Final Acceptance (FA) Punchlist
EPC - DPW - Stormwater Section

Project Name:	Creekside at Lorson F1
EDARP Filing Number(s):	CON1910
ESQCP Number:	ESQ 1911
Attendees:	DPW SW: Natasha Grimaldo, Ben Jones DPW Planning: N/A Developer: Jeff Mark/Lorson LLC
Date of Walk-Thru:	2/14/2023
Walk-Thru Number:	1 st

DATE: SEPT 19, 2019
PROJECT NO. 100.045
SHEET NUMBER C9.2
TOTAL SHEETS: 34

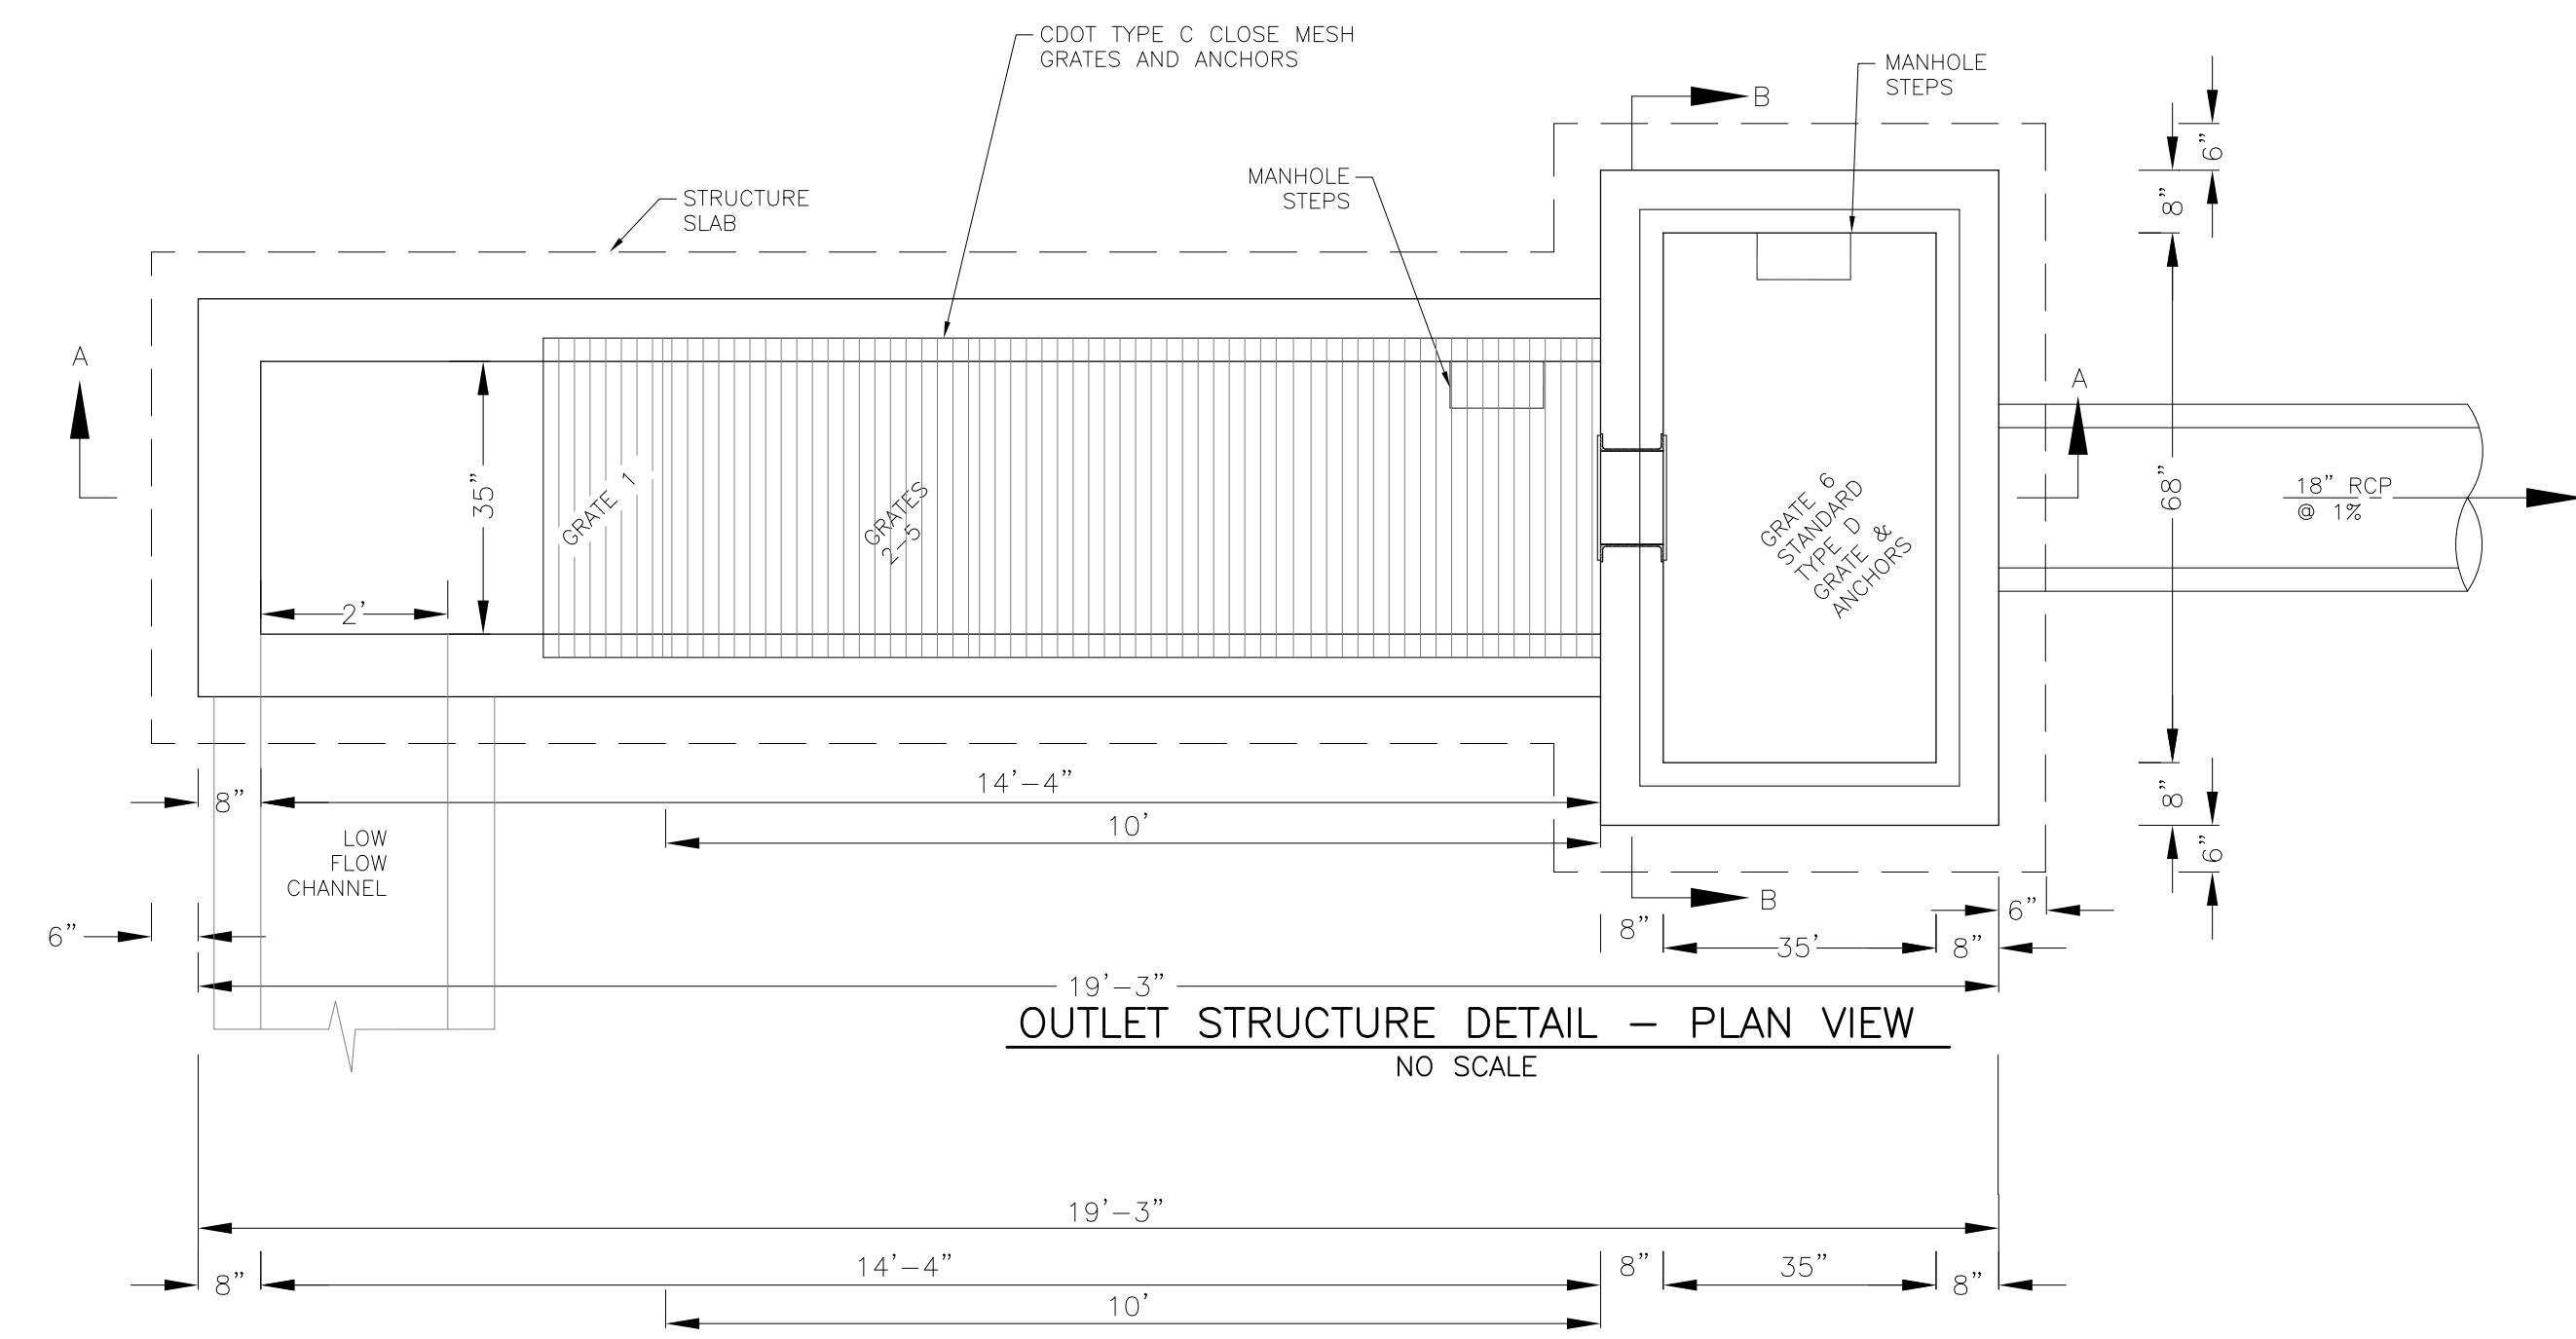
Photo 1: Pond C1-R: Implement missing bolts on outlet structure top grates (approximately 11 missing).

CREEKSIDE AT LORSON RANCH FIL. 1
DETENTION POND CR3 (SFB)
GRADING AND DETAILS

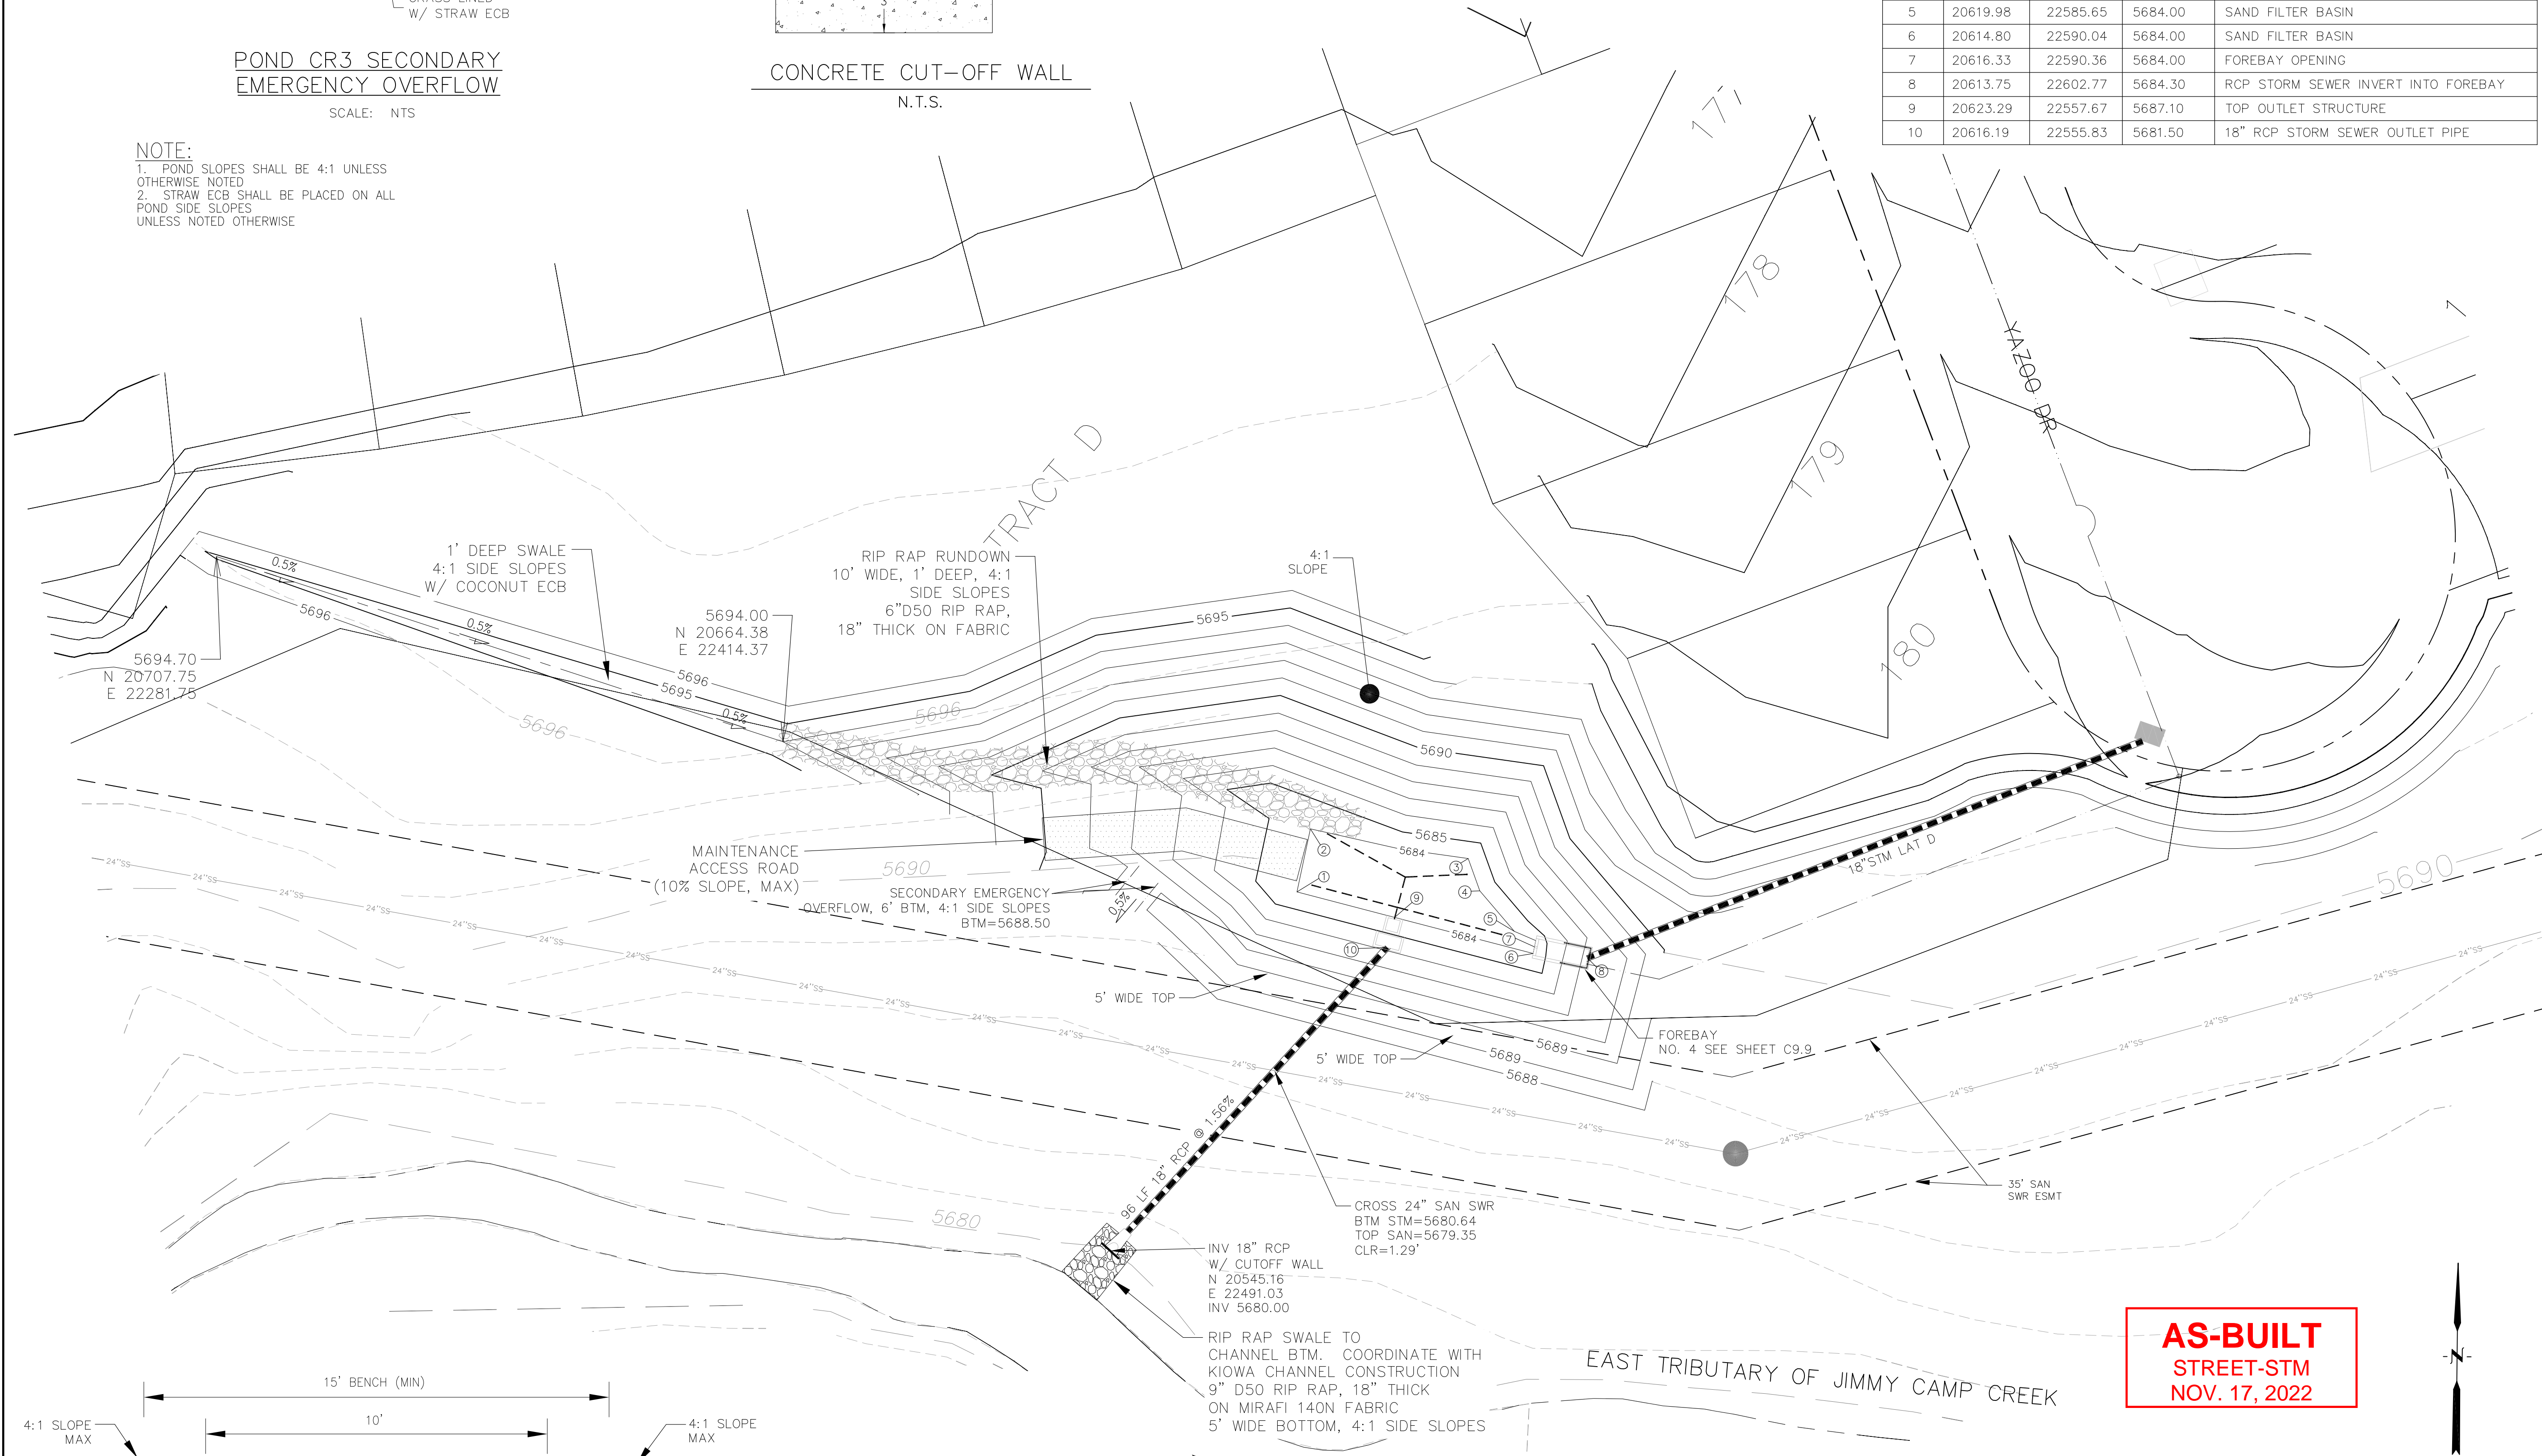
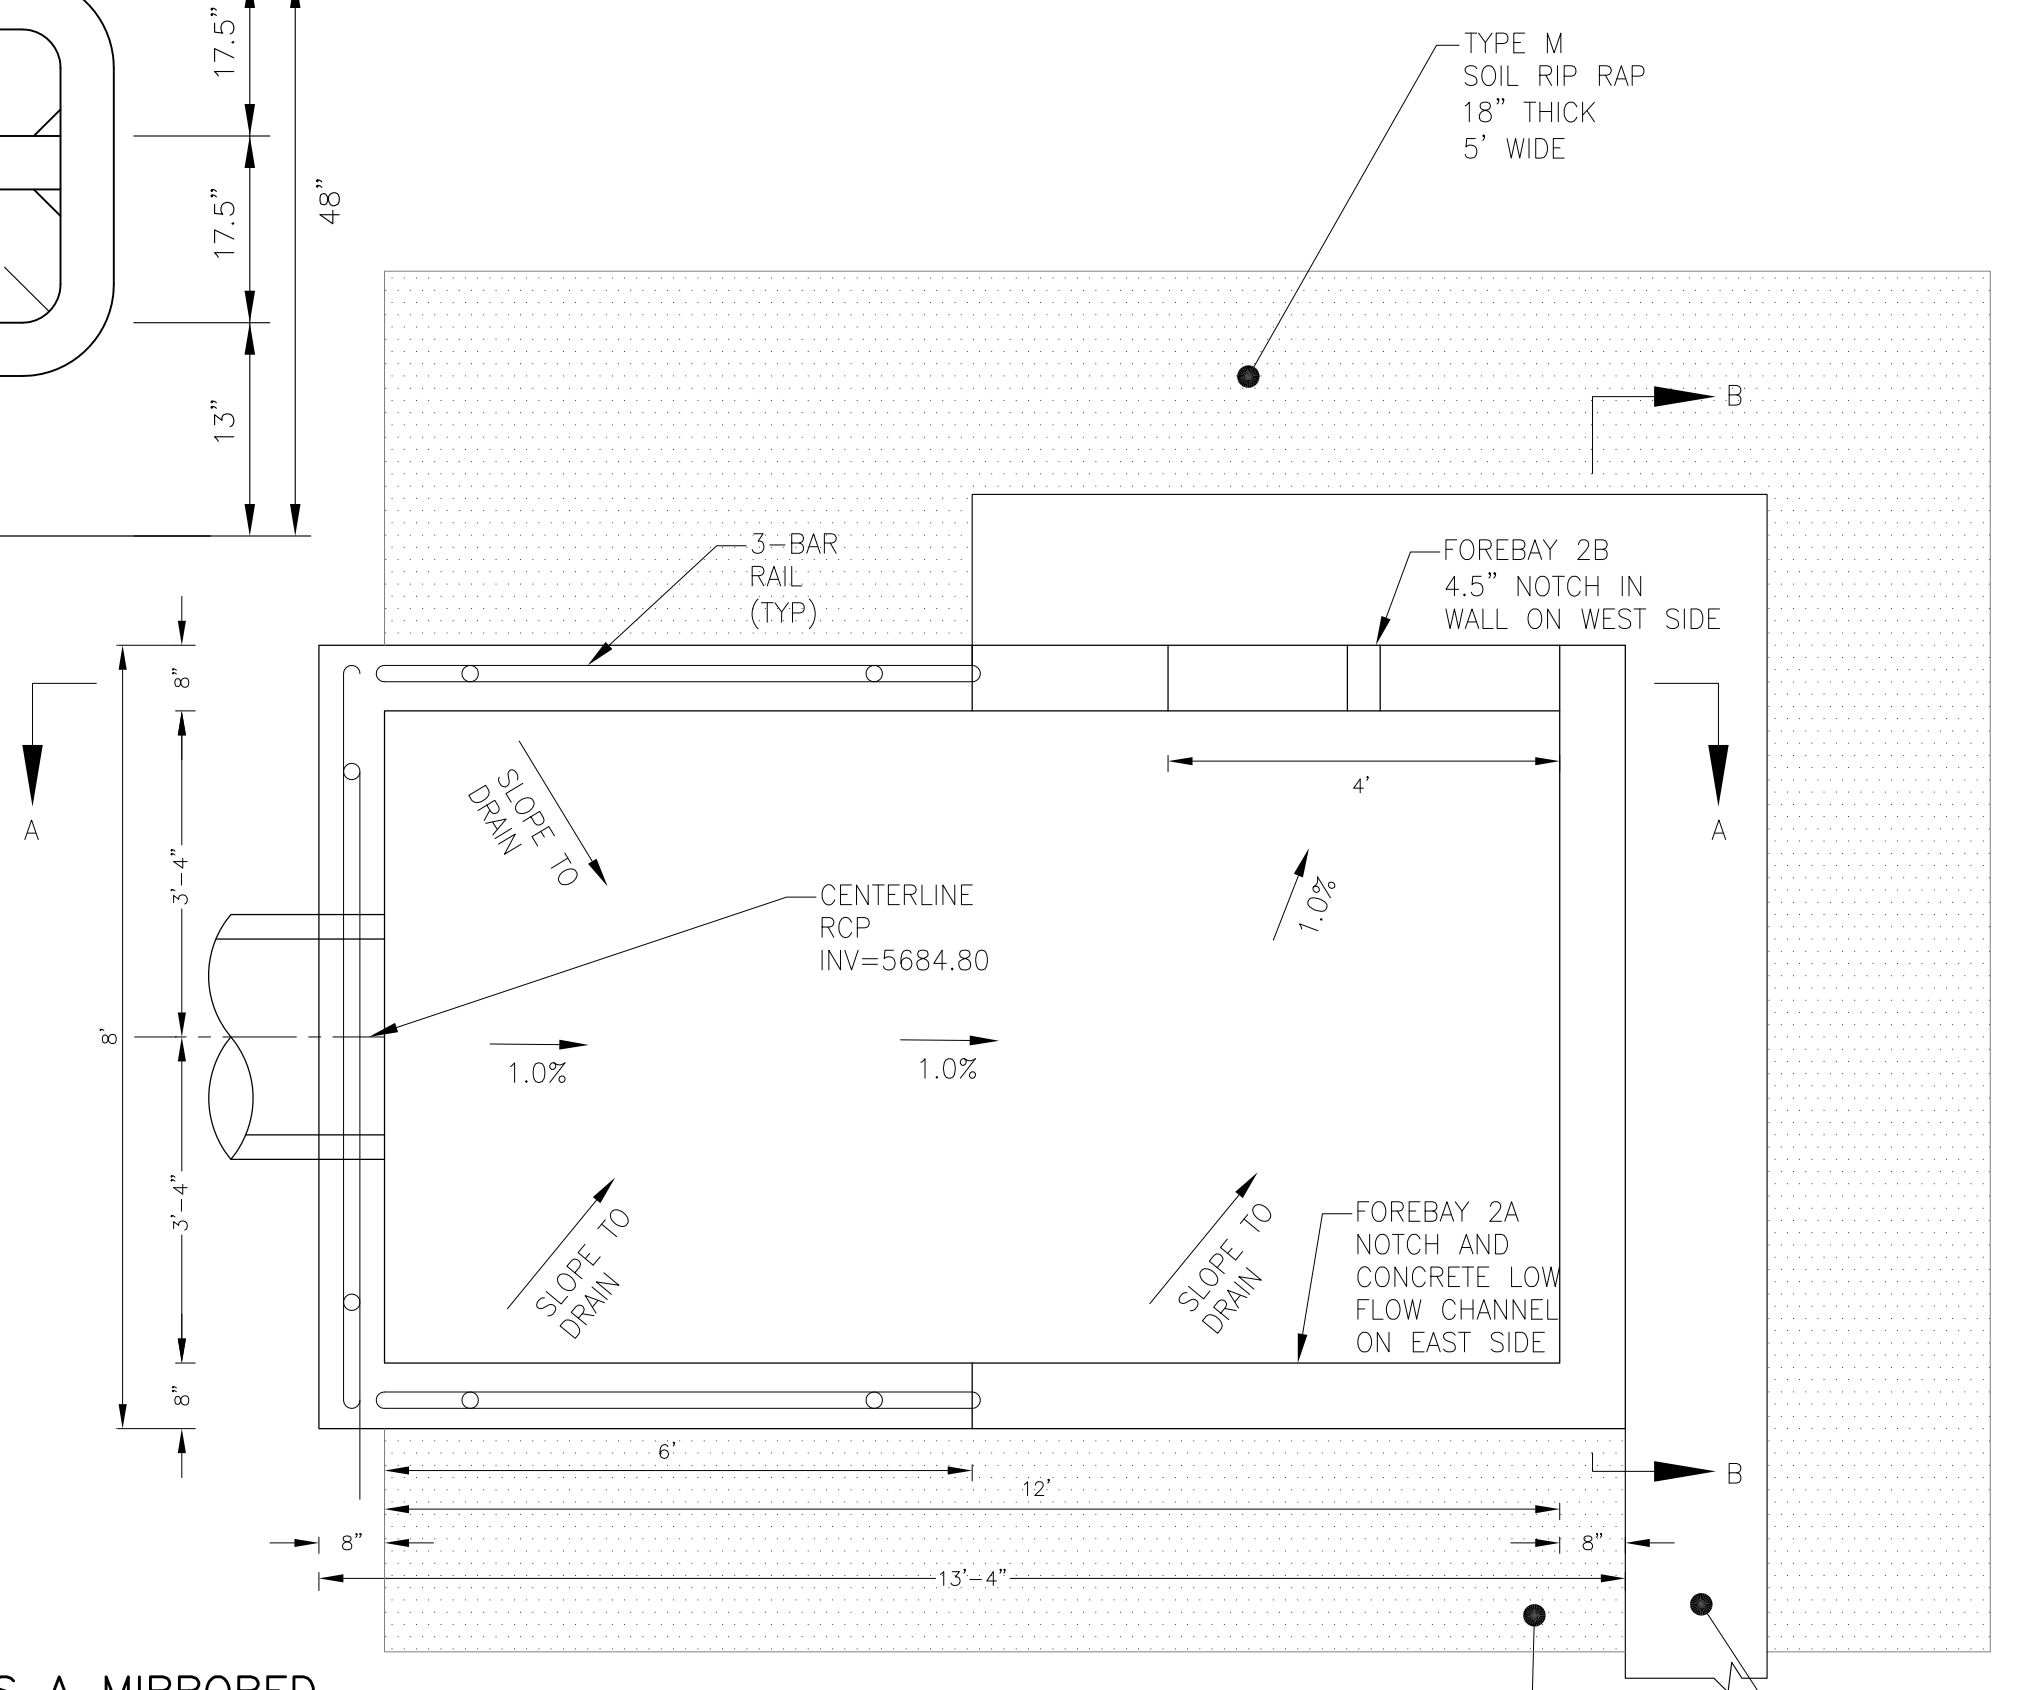
- Remove vegetation from the base of the sand filter basin.
- Failure to implement Steel Restrictor Plate at underdrain outlet. Reference page C9.4 Creekside at Lorson Ranch filing No. 1 Street and Storm Sewer Construction Plans.
- Remove straw wattle from along the access road.

Photo 13: Pond CR3: Failure to implement Steel Restrictor Plate. Reference page C9.4 Creekside at Lorson Ranch filing No. 1 Street and Storm Sewer Construction Plans.
